Application No: AW/315/18/HH

Recommendation Report for Planning Permission for Works or Extension to a Dwelling

LOCATION: 14 Churchill Avenue
Aldwick

PROPOSAL: Retention of fence on front, side and rear elevation.

FENCE

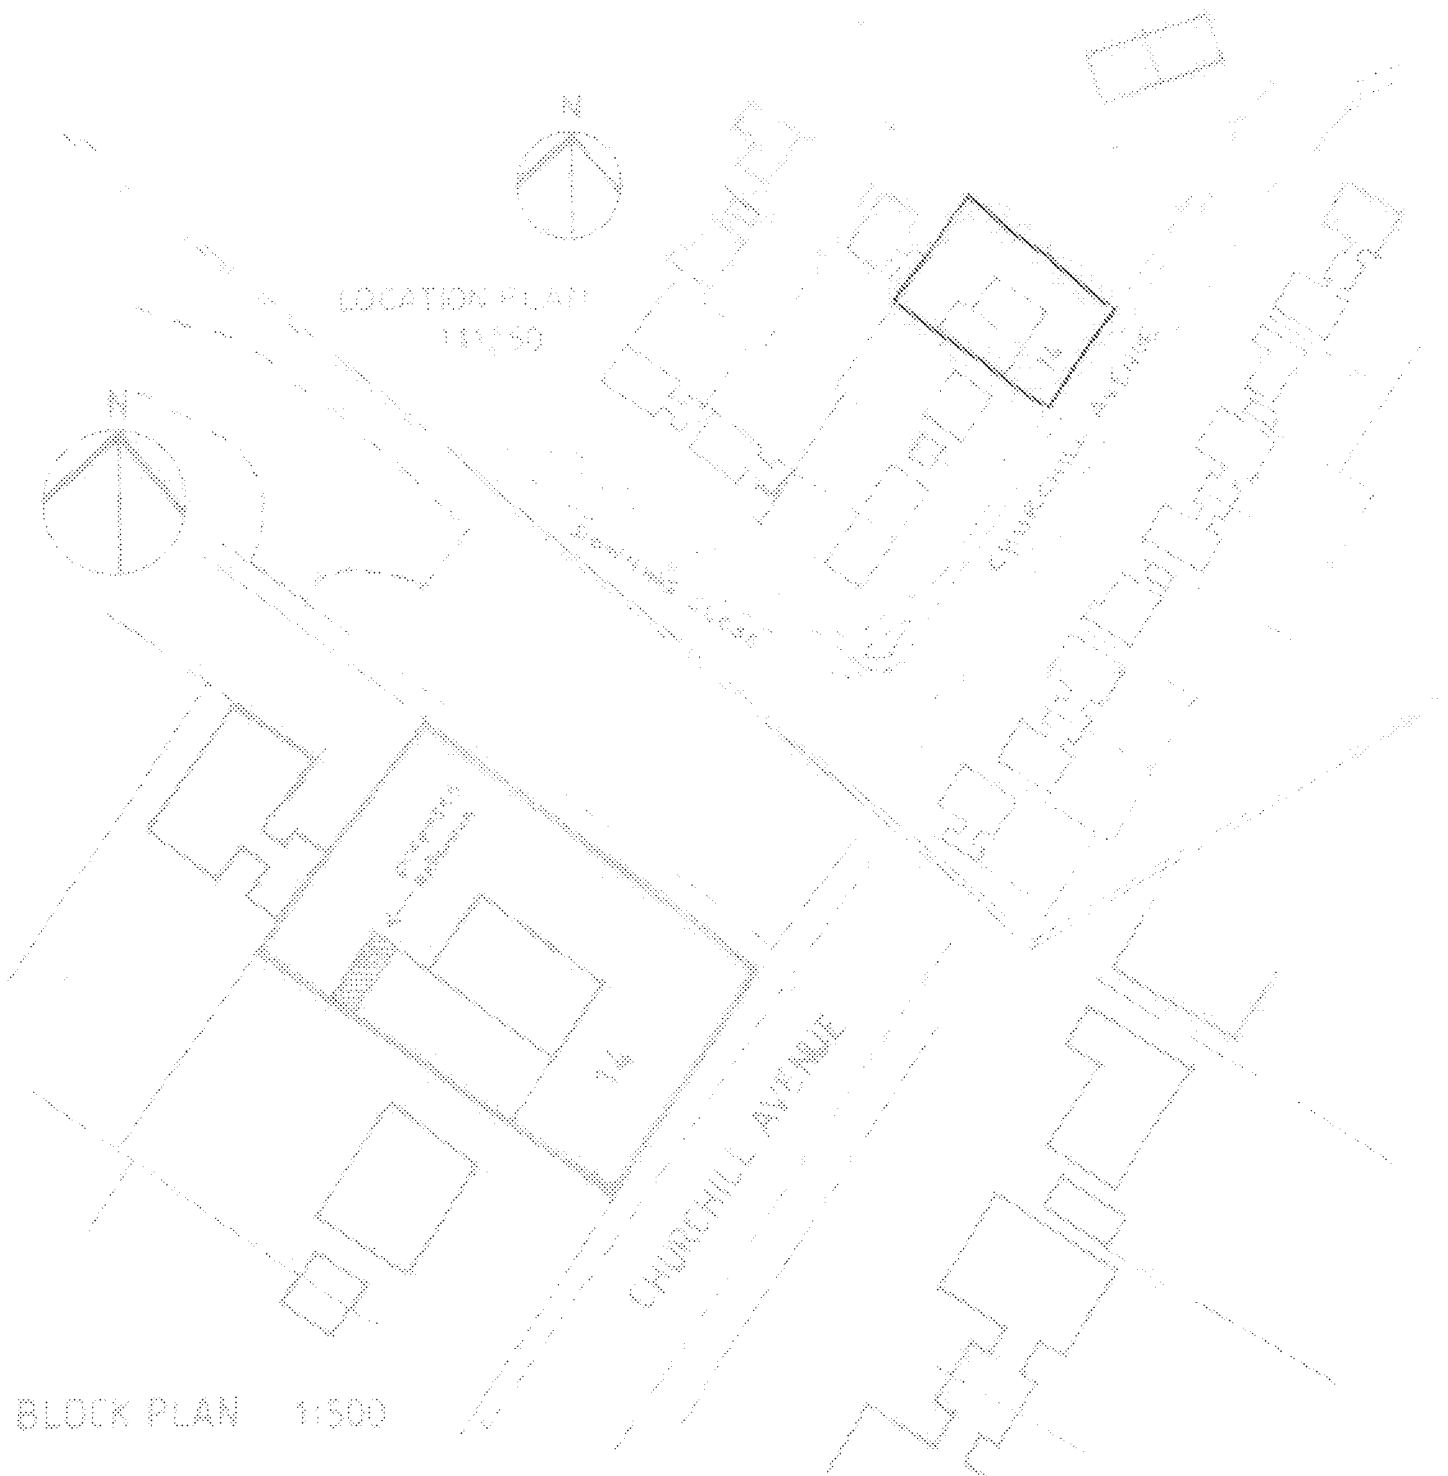
The proposal is sited to the side and rear of the dwelling and as such due to the siting of the development and the dwelling it is visible within the street scene. The fence extends approximately 6m along the front of the dwelling however does not project beyond the principal elevation, 17m along the side of the property and 6m to the rear. The fencing to the rear is screened by hedging.

The dwelling is sited essentially on a corner plot adjacent to an open space with a path alongside the dwelling for access to the rear at Downing Close. The area also has an open plan condition which is evident within the surrounding area with very few examples of boundary treatment to the front of the properties. This makes the fence appear as an alien feature and as a result is also out of character.

By virtue of its siting the fence appears out of character within an open plan estate and as such appears as an alien feature ultimately in conflict with DDM1 of the Arun Local Plan. This impact is reduced by virtue of the enclosure being to the side and rear rather than forward of the existing dwelling.

- 1 The fence shall be removed and all resulting debris removed from the site within 3 months following the applicant ceasing to occupy the property.
